CITY OF ALBUQUERQUE

August 25, 2016

RE: Desert Sands Subdivision, (File: N09D014)
Drainage Report, Engineer's Stamp Date 7-5-2016
Grading and Drainage Plan, Engineer's Stamp Date 8-18-2016

TITLE: ***DESERT SANDS SUBDIVISION
GRADING & DRAINAGE PLAN***

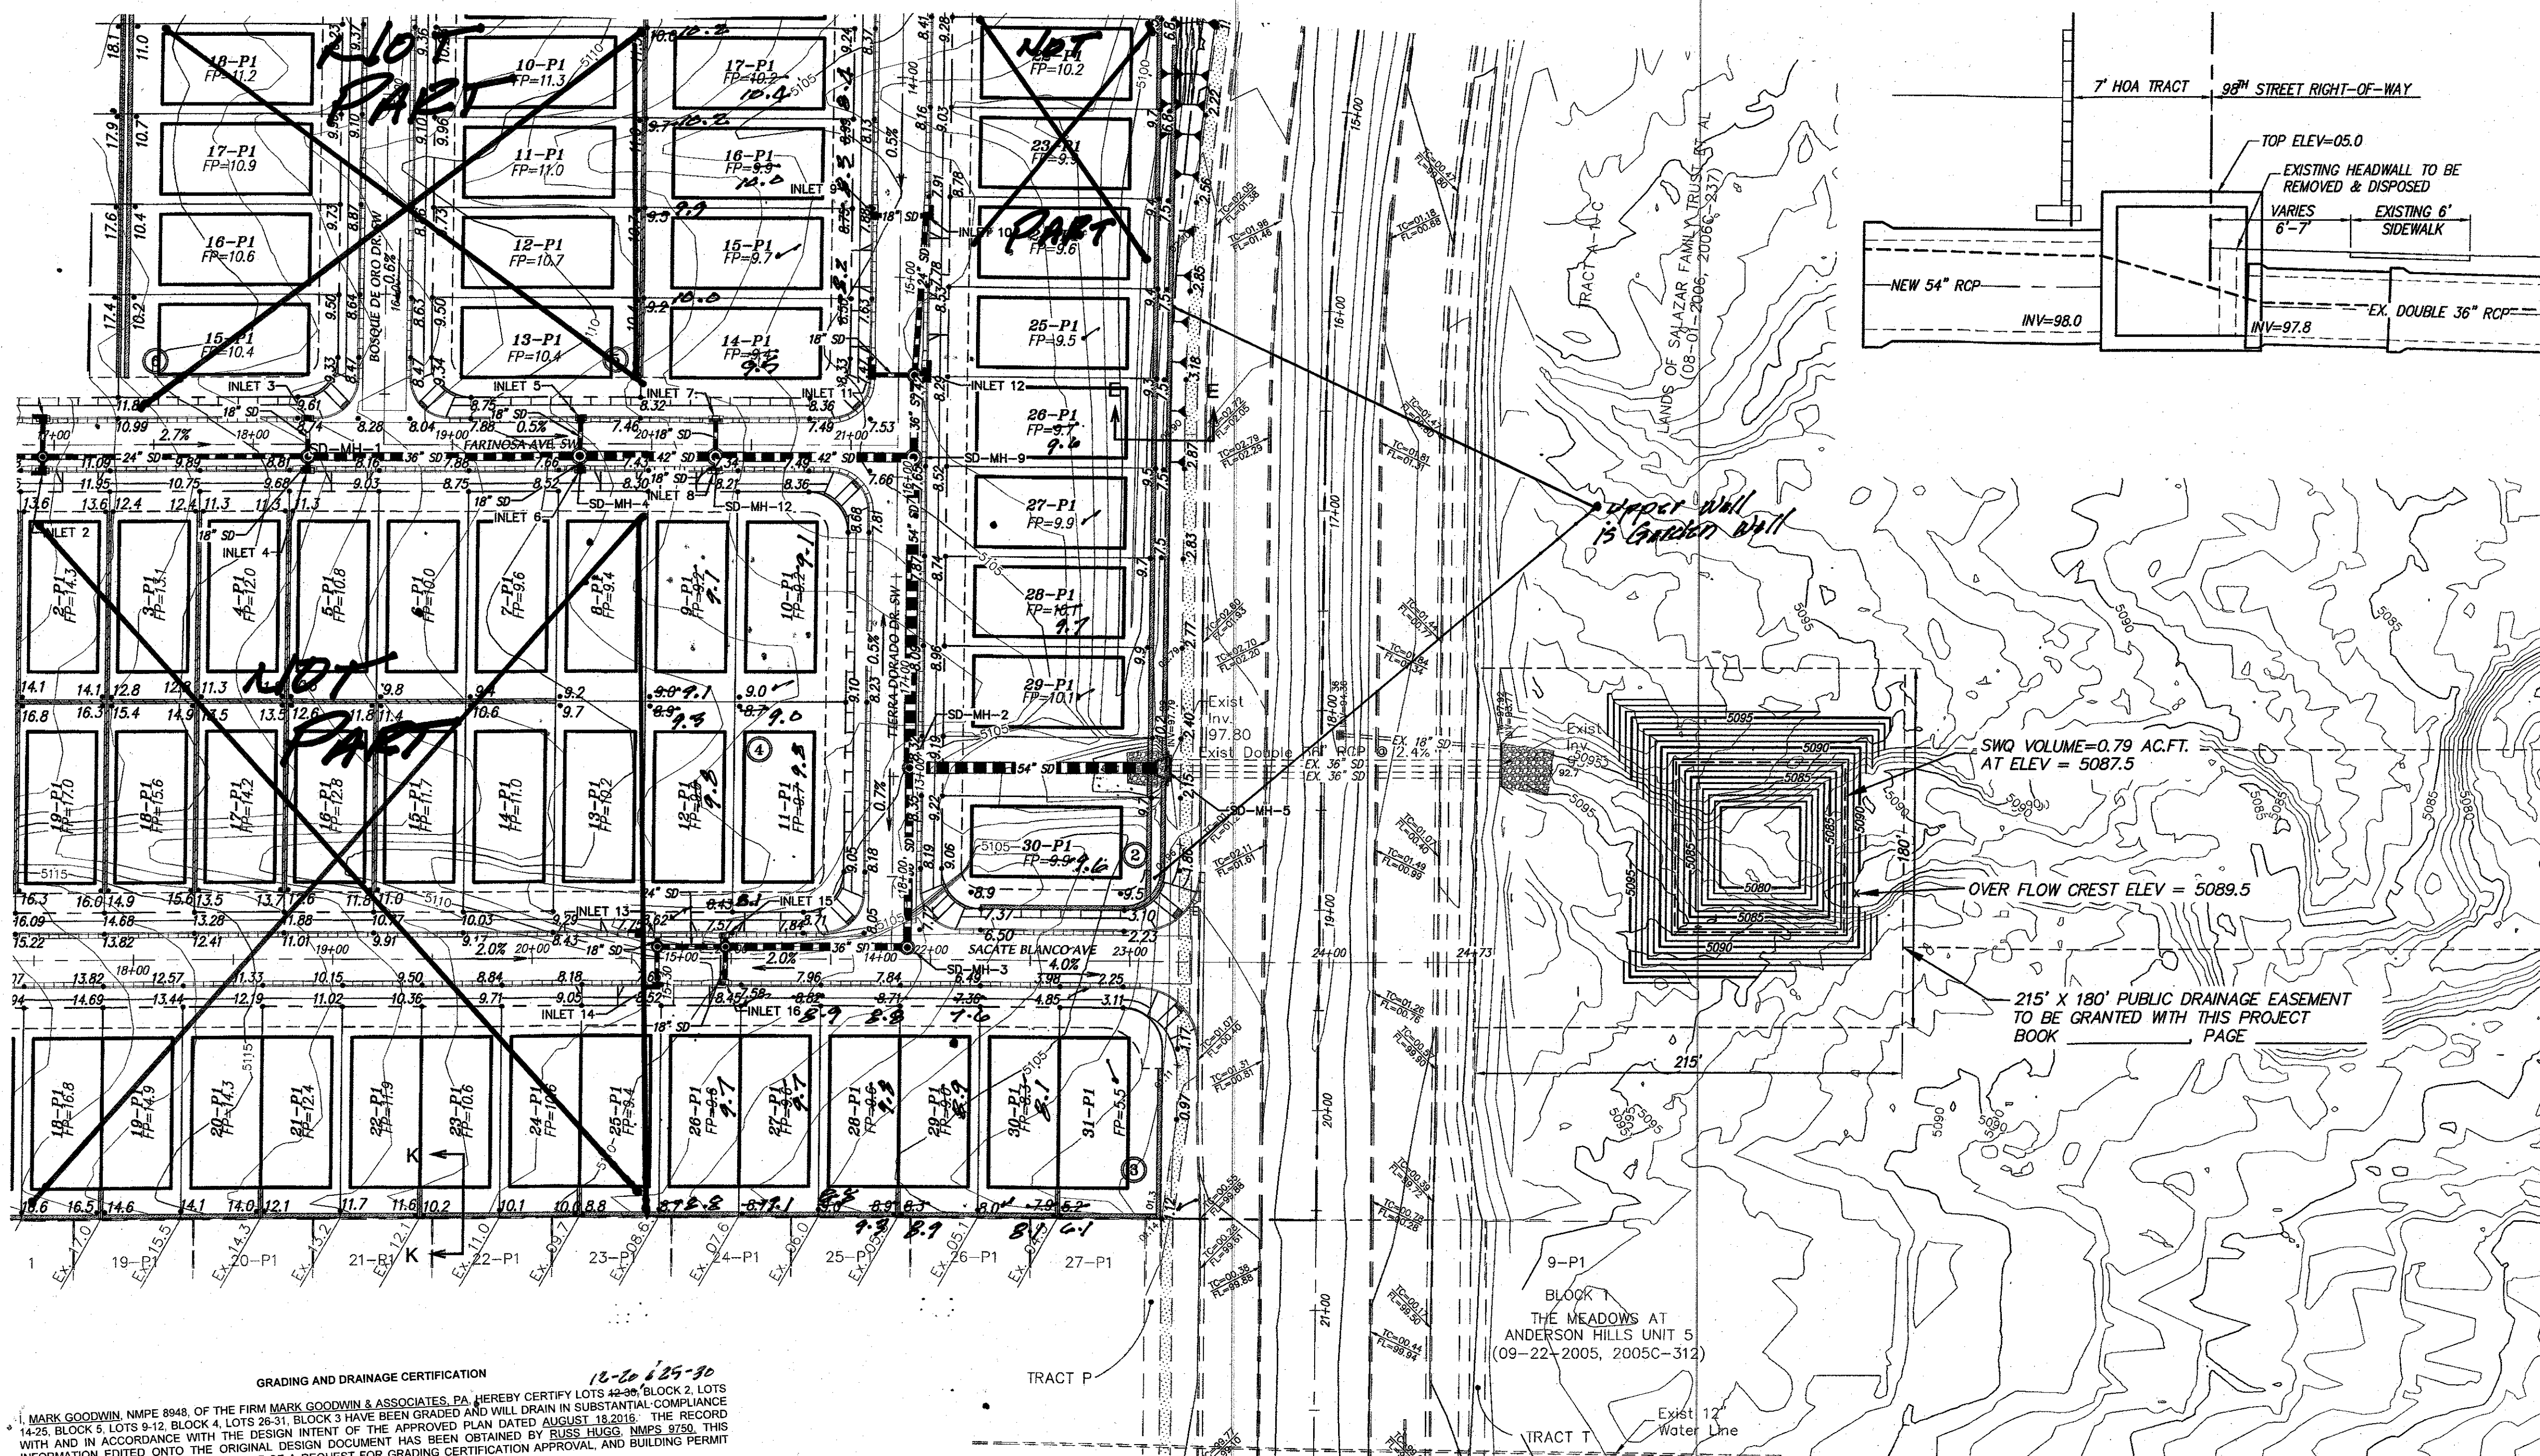
Per a previous email, elevations on east side Kraft Court will be lowered to reflect a 2% cross slope so that flow in the hammerhead can discharge. This change will be reflected on the Work Order and on the Engineer's Certified Plan.
